## **DR. NORMAN JORGENSEN**

### **WRITTEN REPRESENTATION**

#### **HIGHWAYS ENGLAND'S RESPONSE**

- 1.1 *I would like to make the following additional submission in relation to the Highways England Application for an Order Granting Development Consent for the M4 Junctions 3 to 12 Smart Motorway (Case ref TR010019).*
- 1.2 *“During the Accompanied Site Visit in Earley on Tuesday 10 November and at Open Floor Hearing 1 on Monday 16 November I was asked by the Planning Inspector to provide a list of the properties in Earley that I felt are most badly affected by noise.*
- 1.3 *There are many properties in Earley affected by noise because of the topography of the area. Earley is a Town of population approximately 30,000 people and approximately 13,000 dwellings. Around a third of the Town is close to and on a slope rising from the motorway hence there are people some way from the motorway that experience high levels of noise if they are not screened by other houses or natural features.*

Project	SMART MOTORWAYS PROGRAMME
	M4 JUNCTIONS 3-12
Drawing title	ENVIRONMENTAL MASTERPLAN
	REGULATION 4(2)(e)
	SHEET 14 OF 61
	LOWER EARLEY

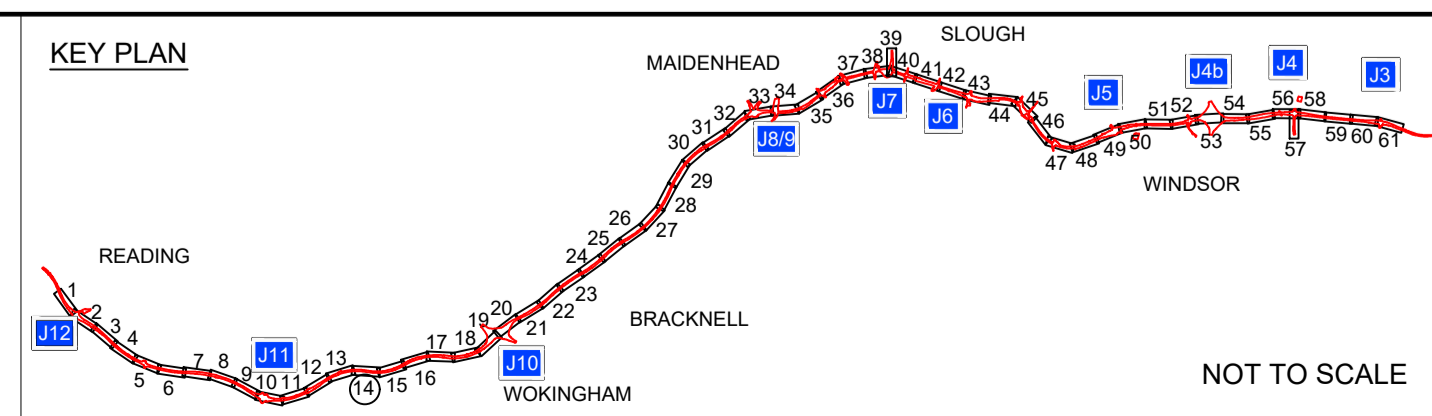
*The houses closest to the motorway with little or no protection from noise are in the housing estates off Ryhill Way and off Bradmore Way. More specifically I believe the worst affected houses are those at 28-34 Finbeck Way (RG6 4AH) and 30 to 40 Notton Way (RG6 4AJ). Standing in front of these properties there is direct line of sight to the vehicles going by on the motorway.*

- 1.6 *Other properties in the vicinity are close behind and these include 39-67 Maltby Way, 5-8 Heacham Close, 42-64 Notton Way, 7-12 Tickhill Close, 17 Worrall Way, 23-27 Bradmore Way, 11-25 Rainworth Close, 1-5 Farnsfield Close and properties in Cutbush Close and Redhouse Close.*

- 1.7 *I will be happy to take the Planning Inspectors and/or Highways England to these locations if that would help.*

- 1.7.5 Highways England confirms that the Lower Earley area was subject to the assessment undertaken as part of the enhanced noise mitigation study. The confirmed barrier provision in this area is detailed within Appendix E of the Enhanced Noise Mitigation Study Report (Ref 514451-MUH-00-ZZ-RP-EN-400158), Sheet 4 is relevant to the Lower Earley area.

- 1.7.6 The results of the enhanced noise mitigation study show that an additional 2126 metres of 2.5 metre high noise barrier is to be provided adjacent to Lower Earley. The provision of this mitigation will provide further noise decreases to properties in Lower Earley, in addition to the minor noise decreases on Scheme opening (without enhanced mitigation) presented in Sheet 4 of Drawing 12.4 of the ES (Application Document Reference 6-2, APP-266).
